CITY OF PORTLAND

September 2, 2004

RE: 199 Hope Avenue: Wetland Encroachment

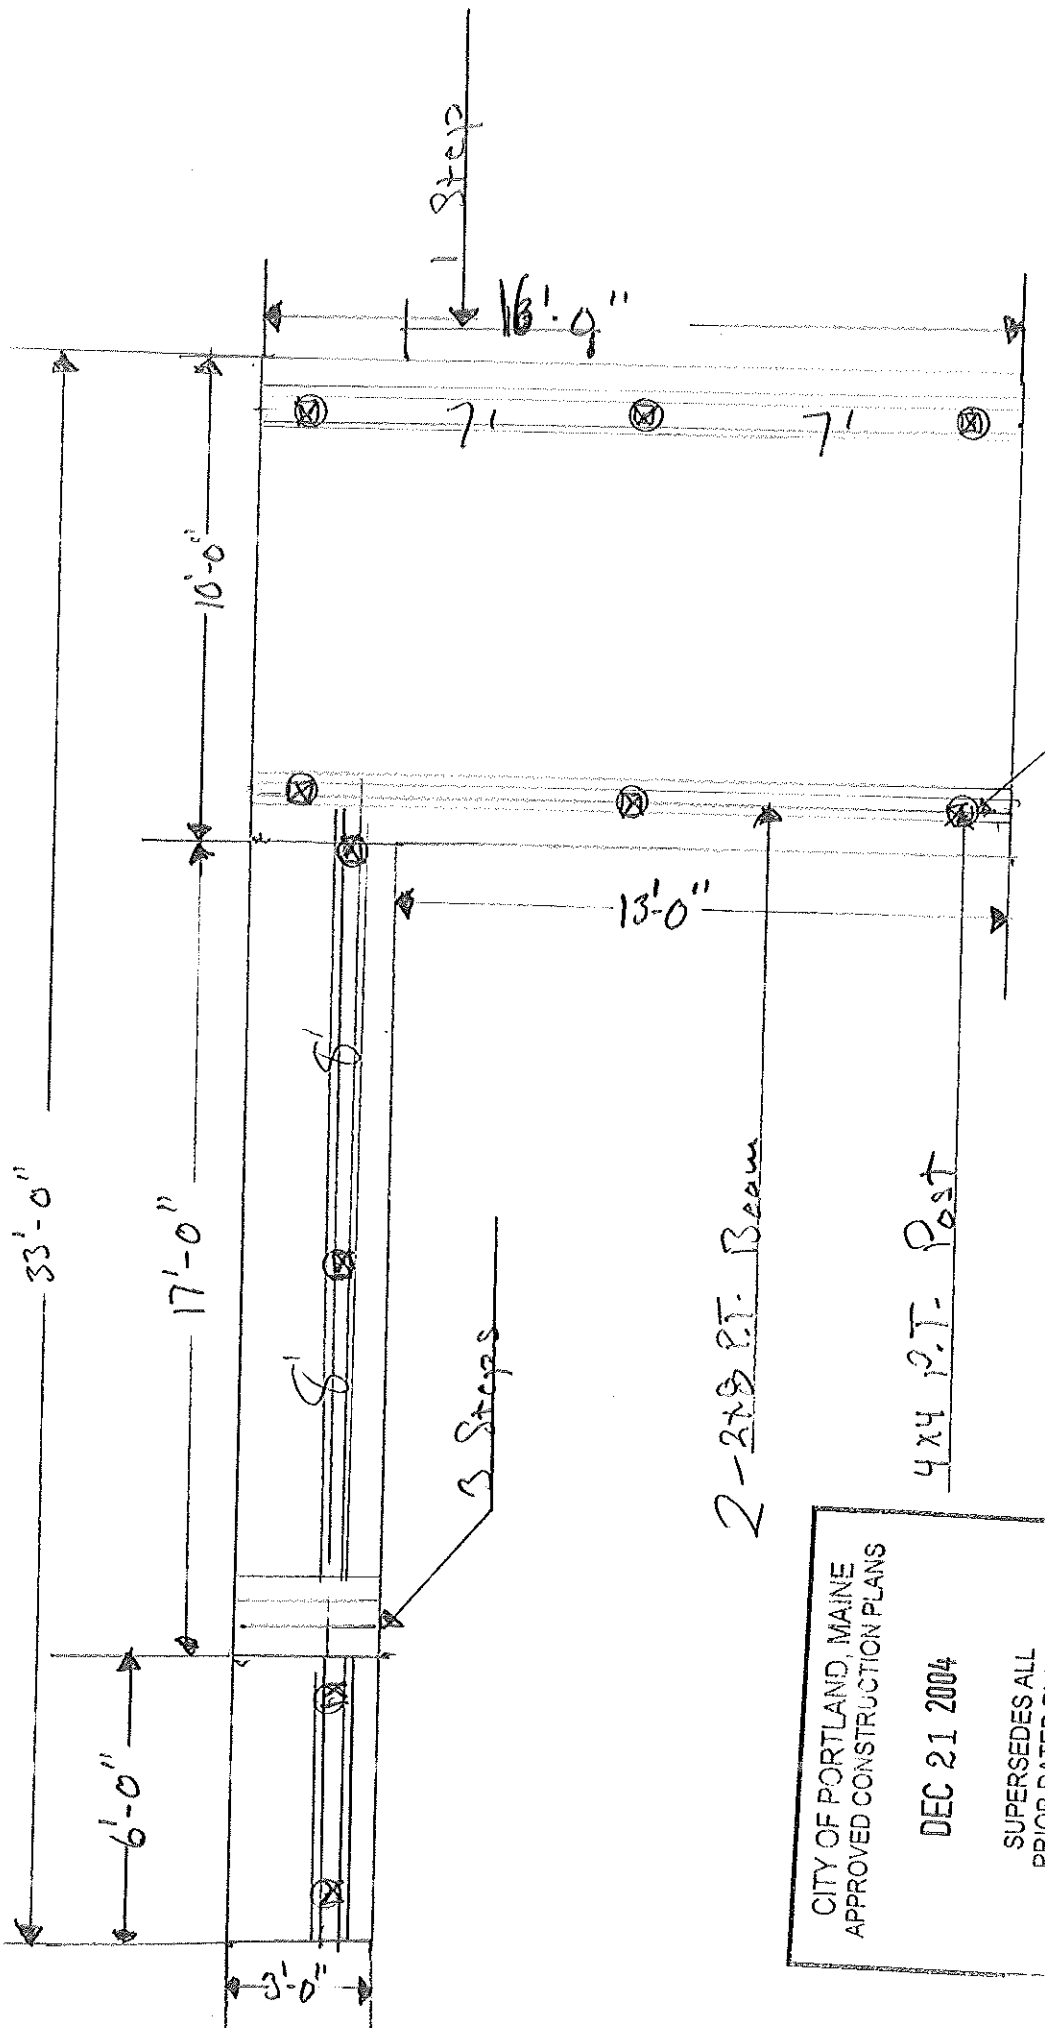
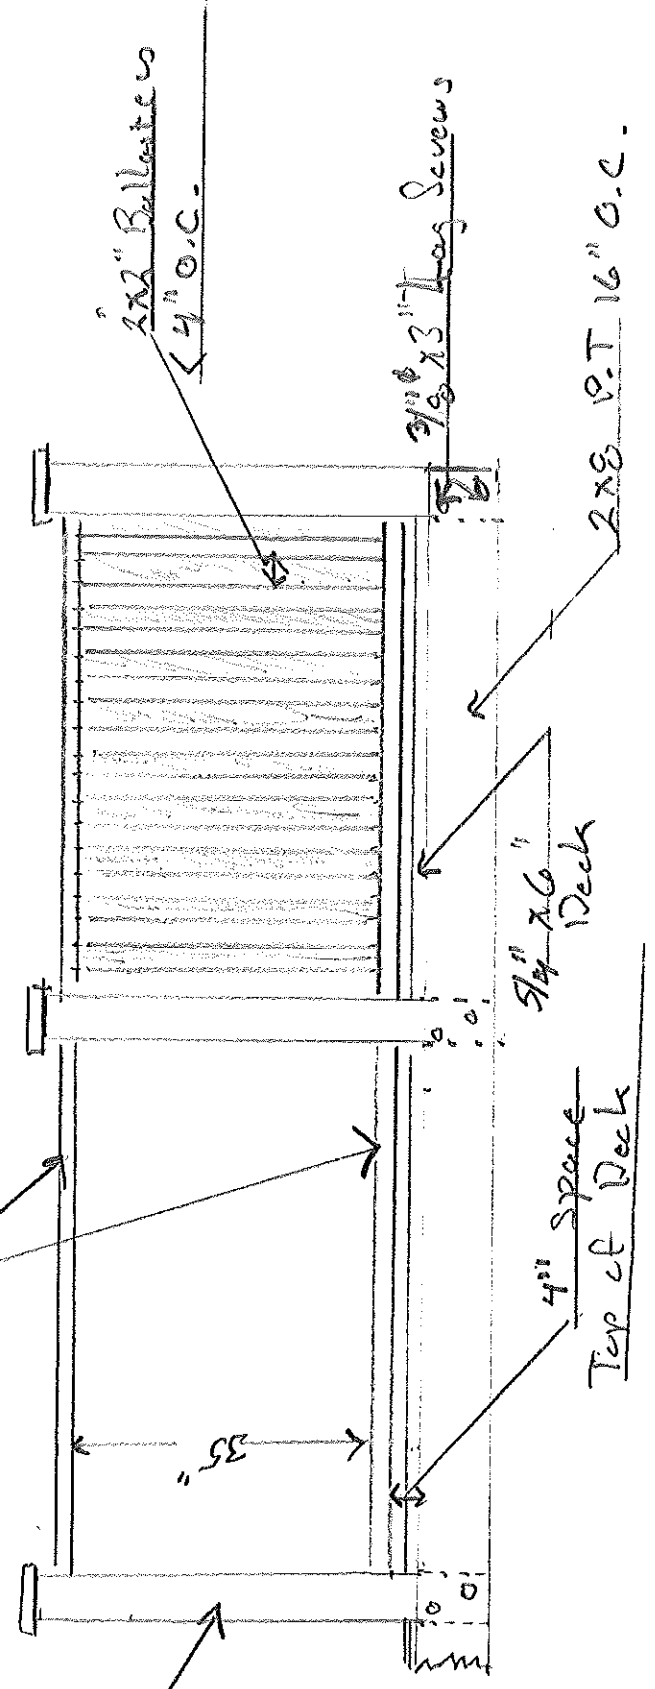
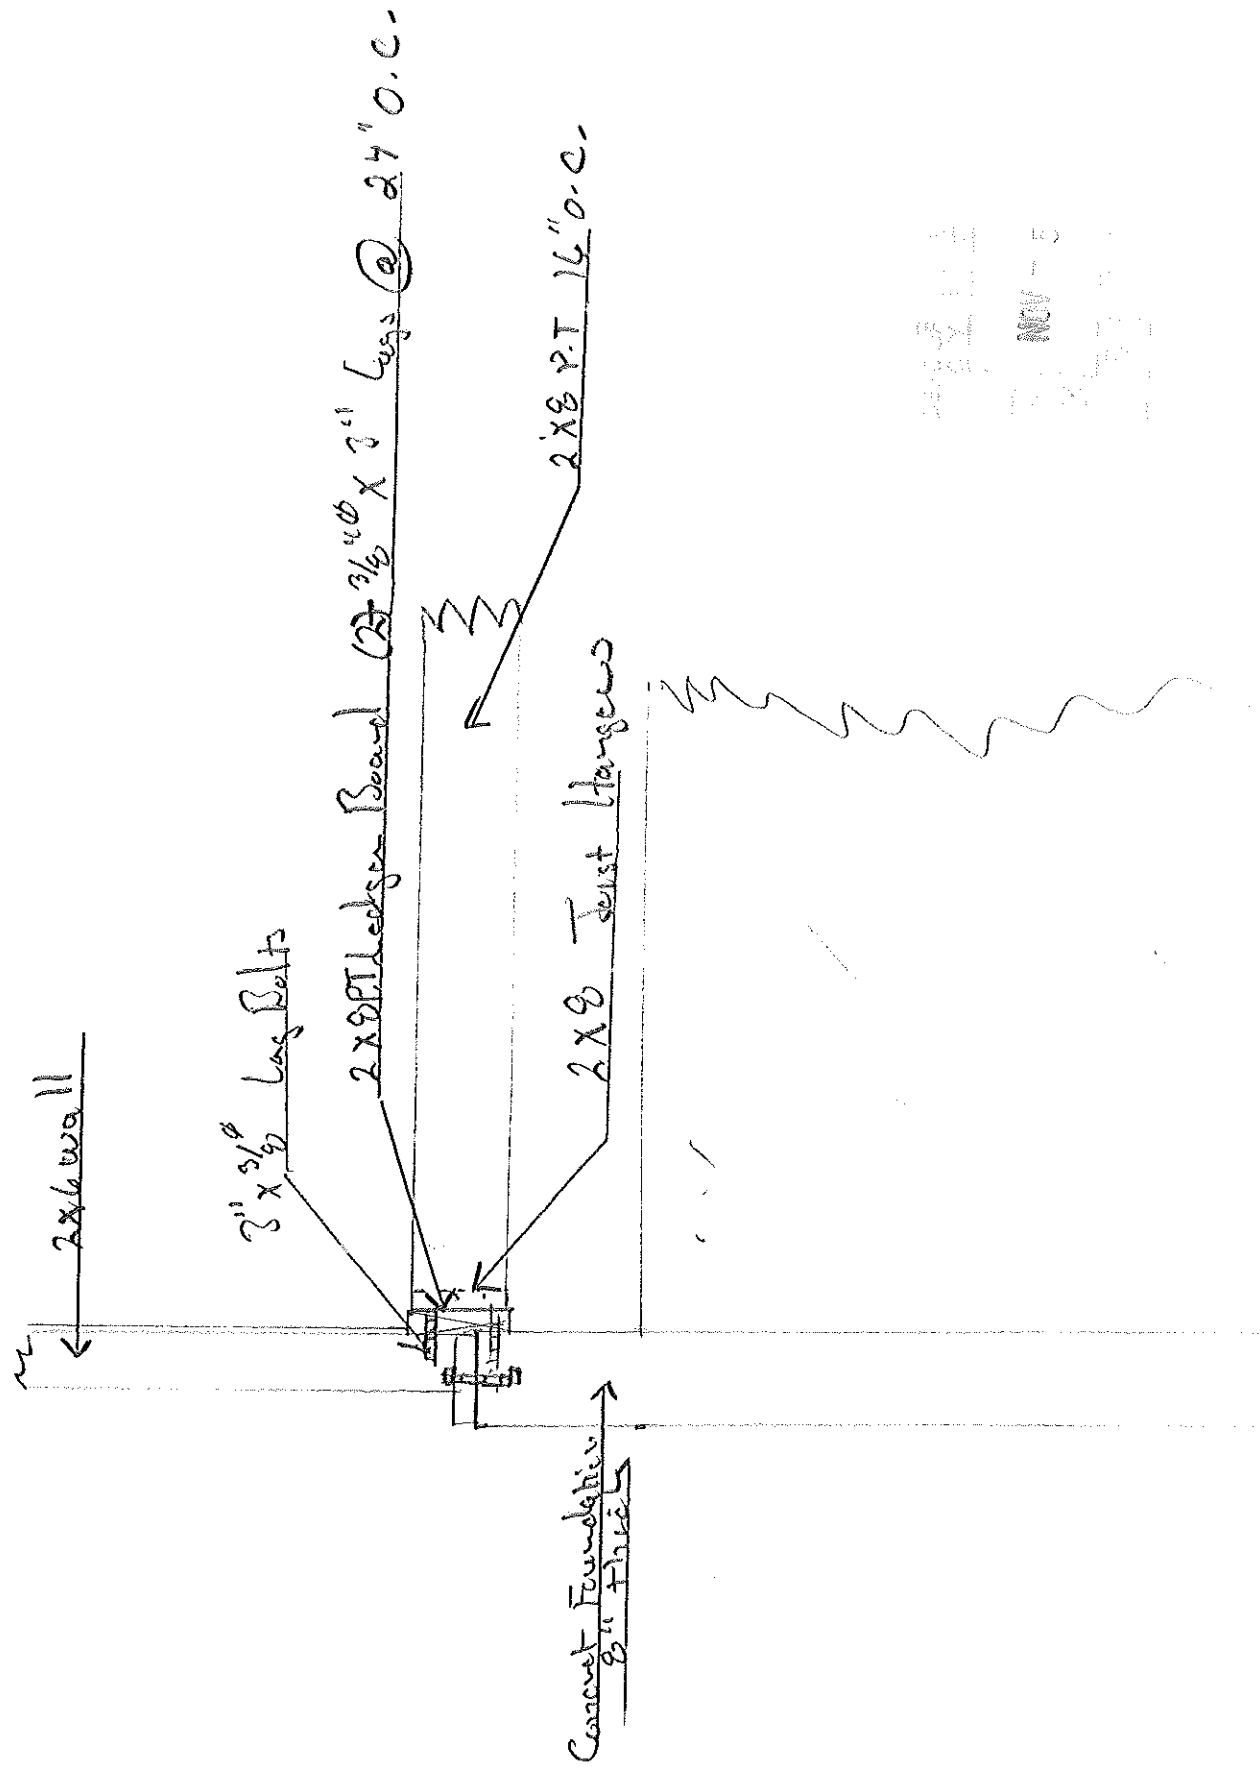
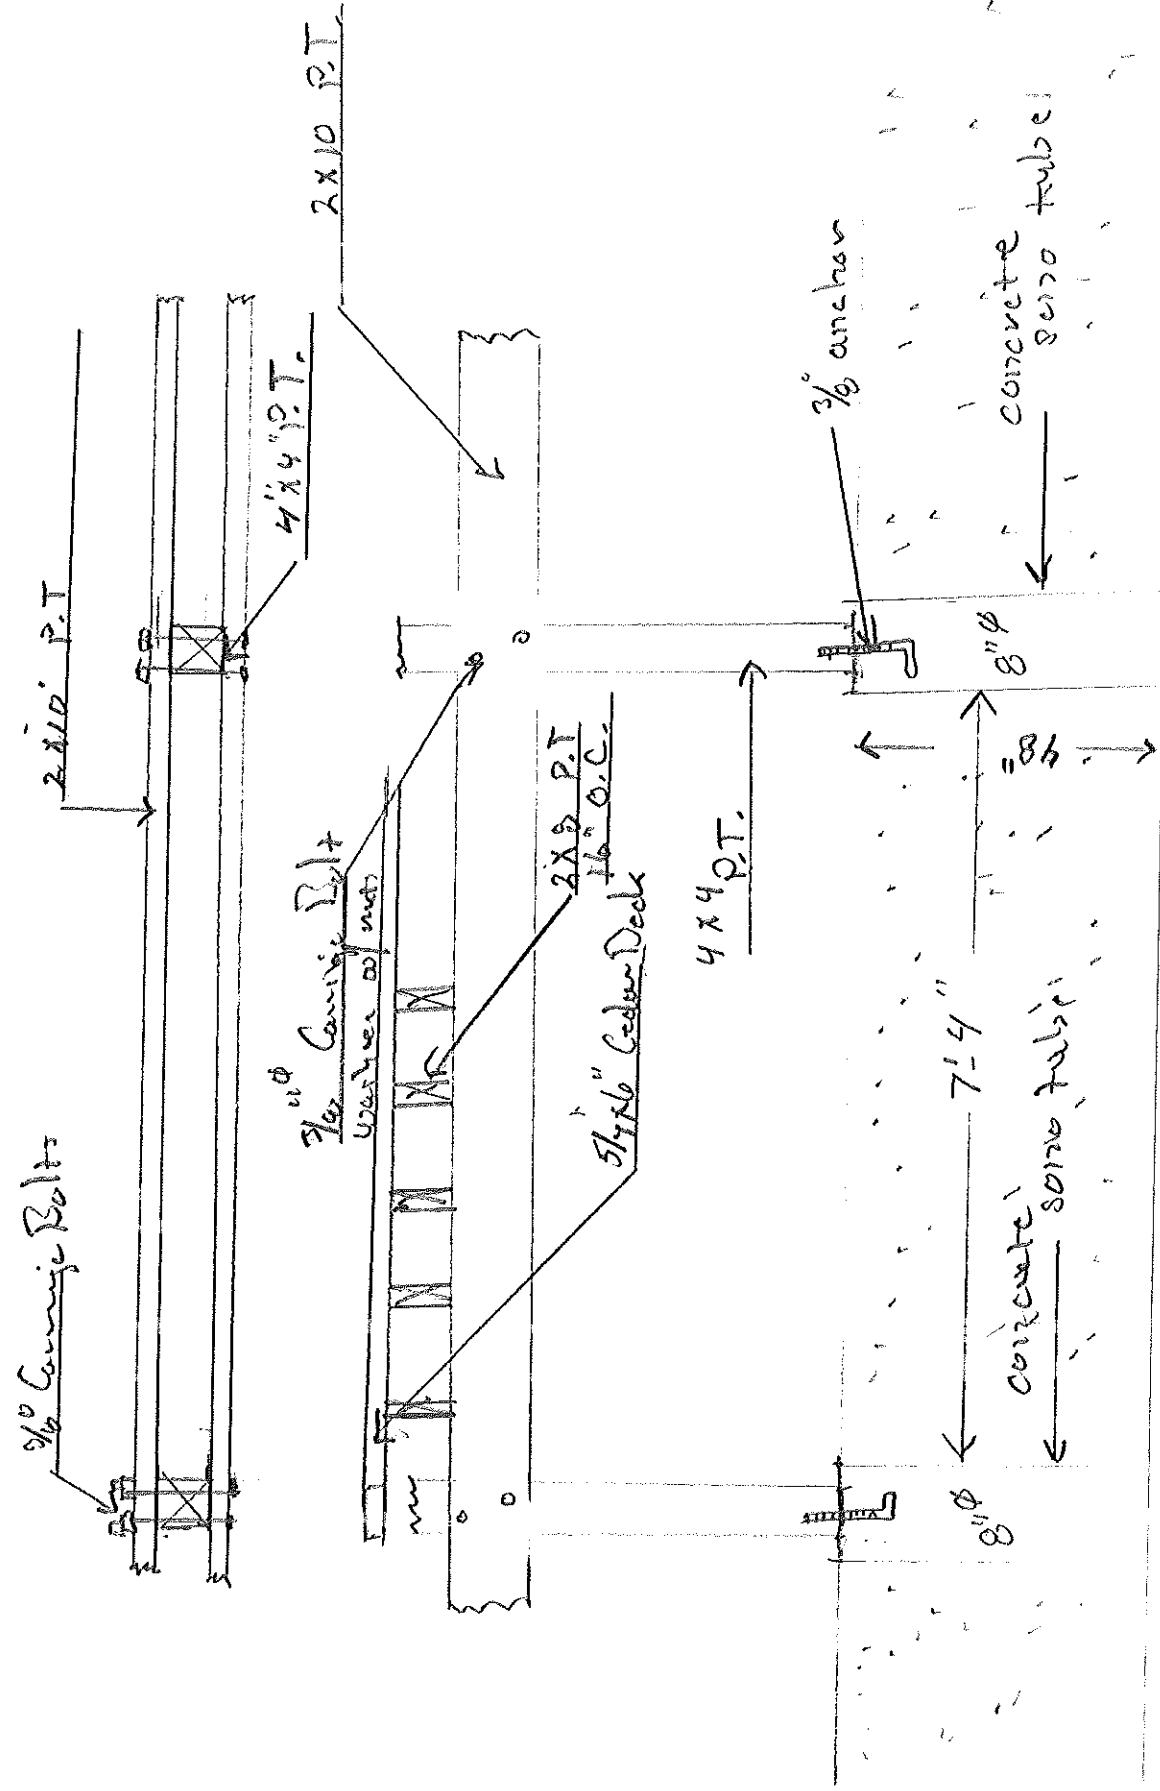
Once items 1 and 2 are completed, the City will be in a better position to evaluate the deck's permit application.

Also, the proposed deck falls outside of the building envelope. Certain lots in this subdivision require additional approvals to build outside of the building envelope. I will discuss this with our development review team to determine if this is required, and if the City would grant such a request.
